Memorandum

Subject: Joe White Malting, Minto (MP 08-0157, MOD4)

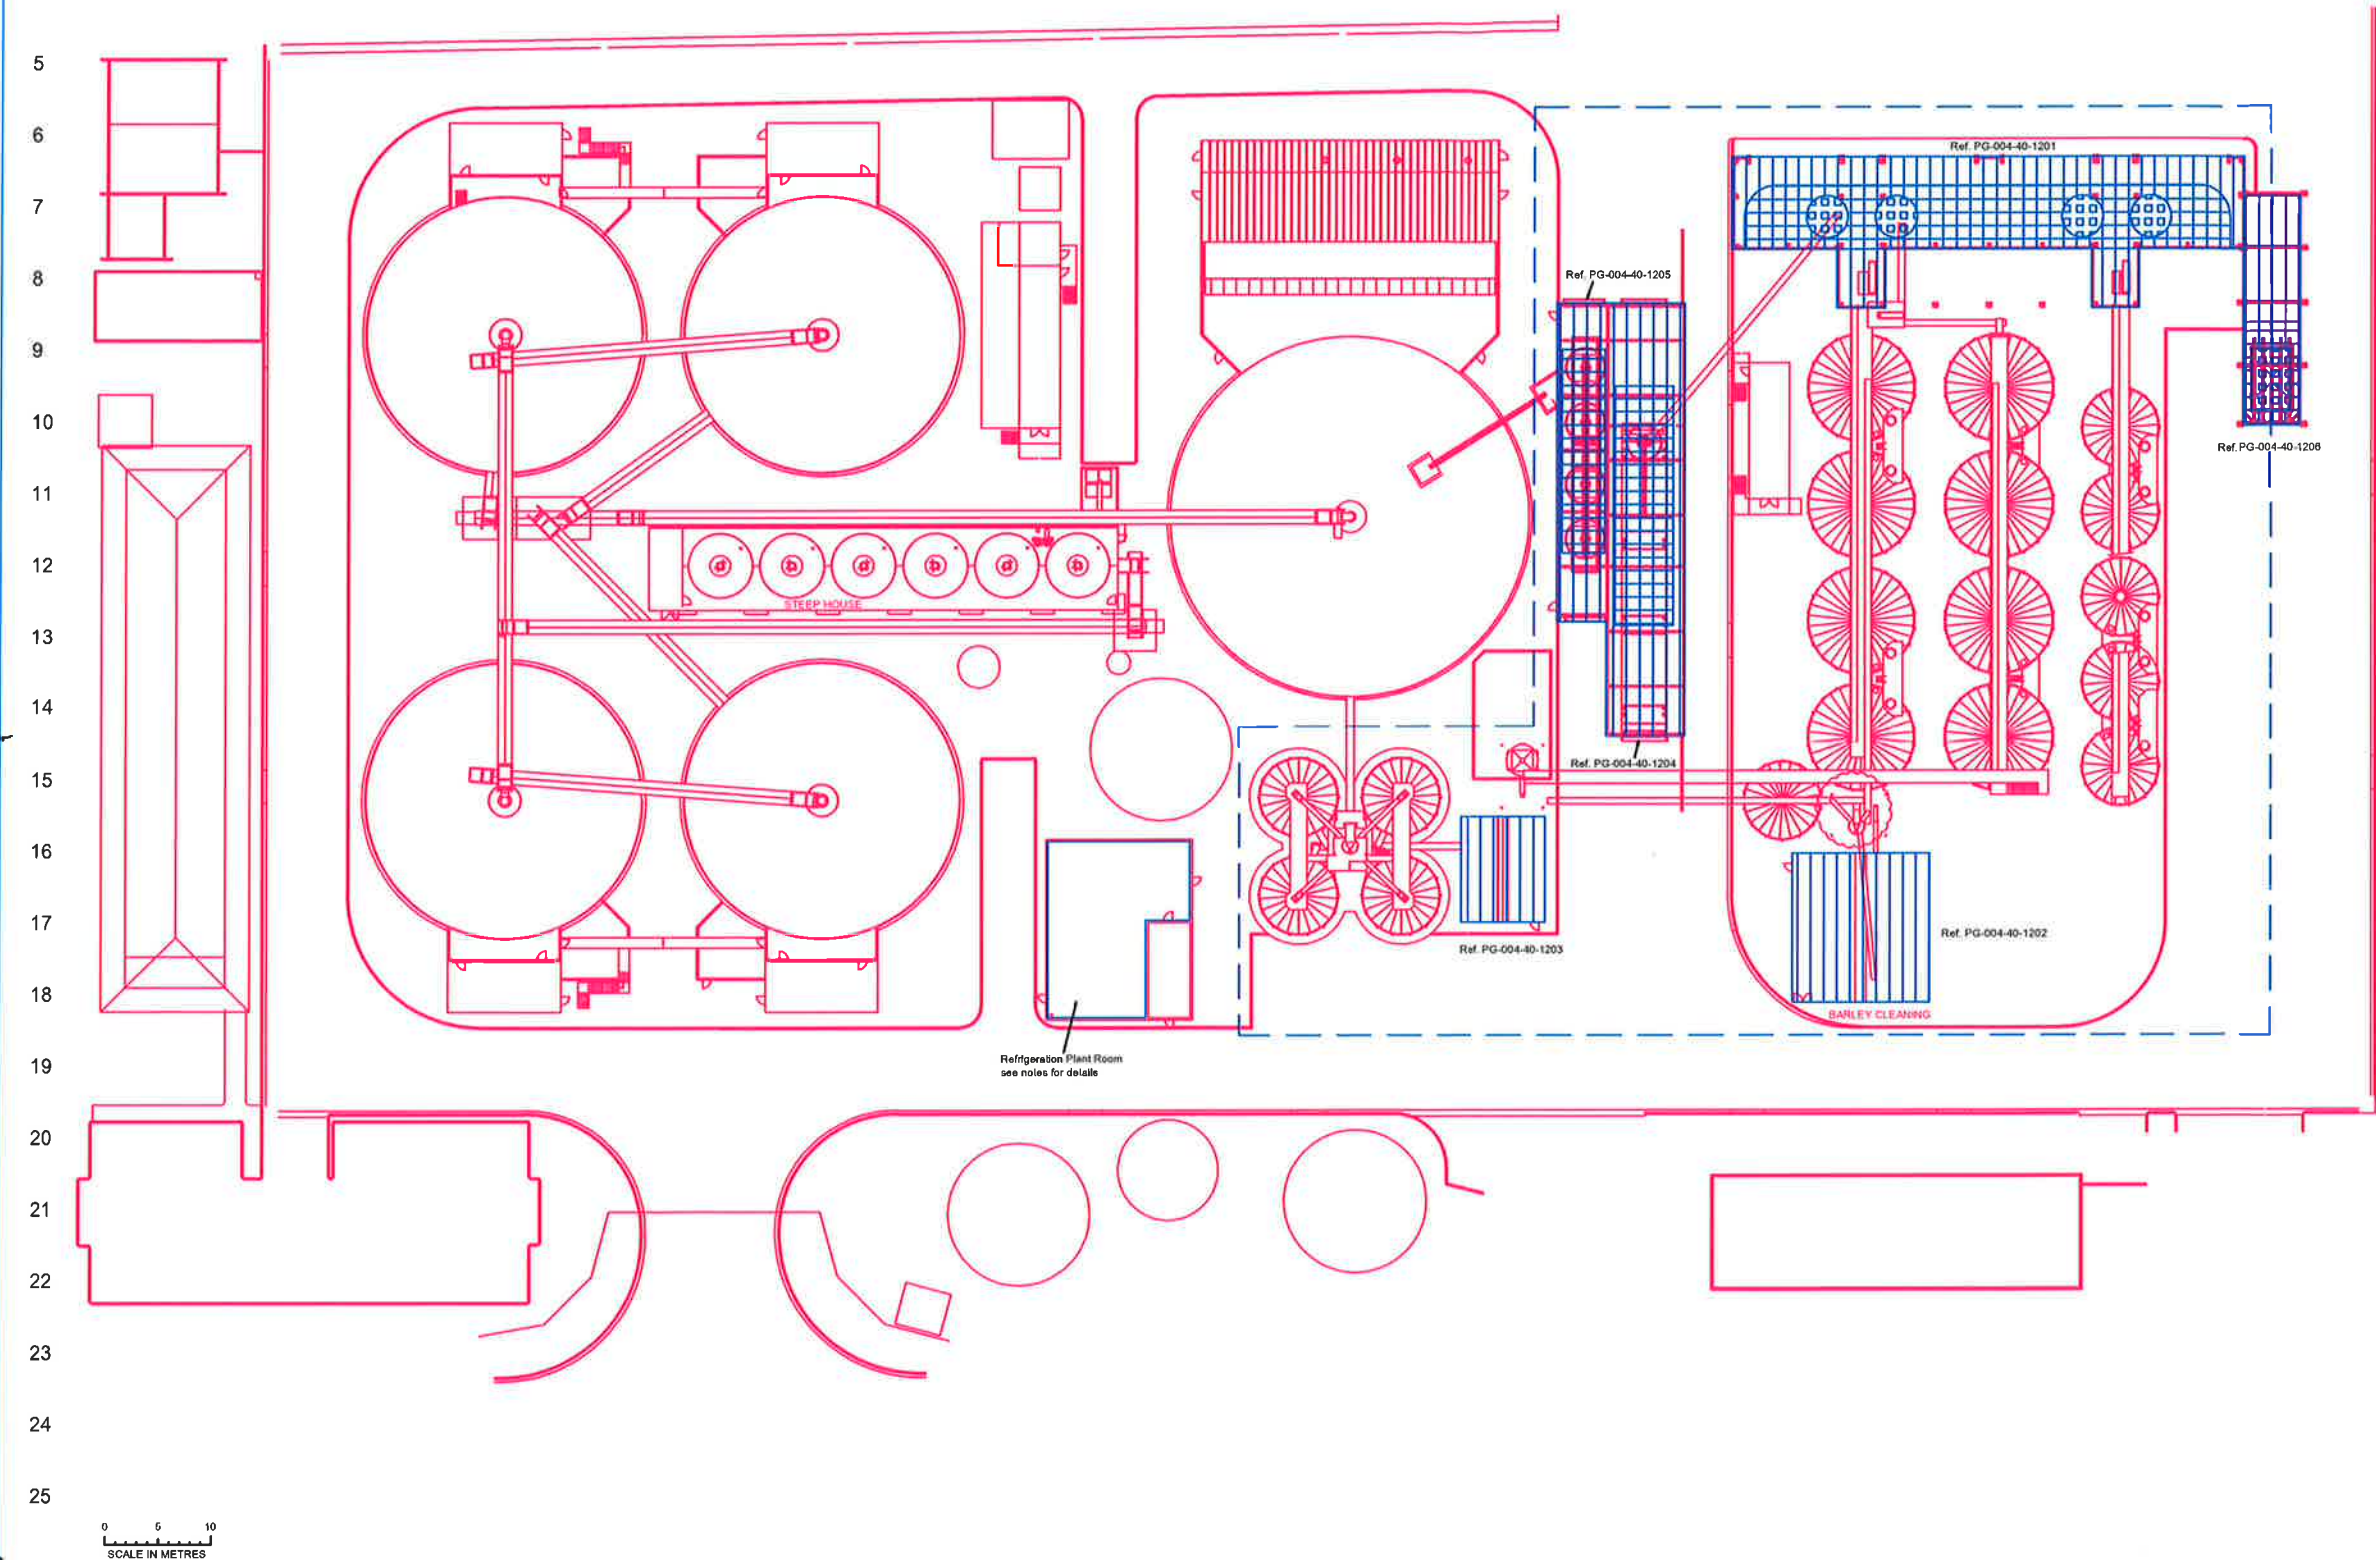
1. Further information is sought around the proposed road truck importation method of transfer, duration of truck transfers, operational safeguards, preventative and mitigating controls and the current adequacy of facility to accommodate and prevent dust cloud emissions and fires in the unloading bay.

2. Original plant design included an option to receive barley by road in an emergency situation. The MOD 4 proposal, will now increase the overall frequency of importing by road. The plant design should be reviewed to ensure that hazards and risks from grain dust fires and explosions are assessed and necessary safeguards in place.
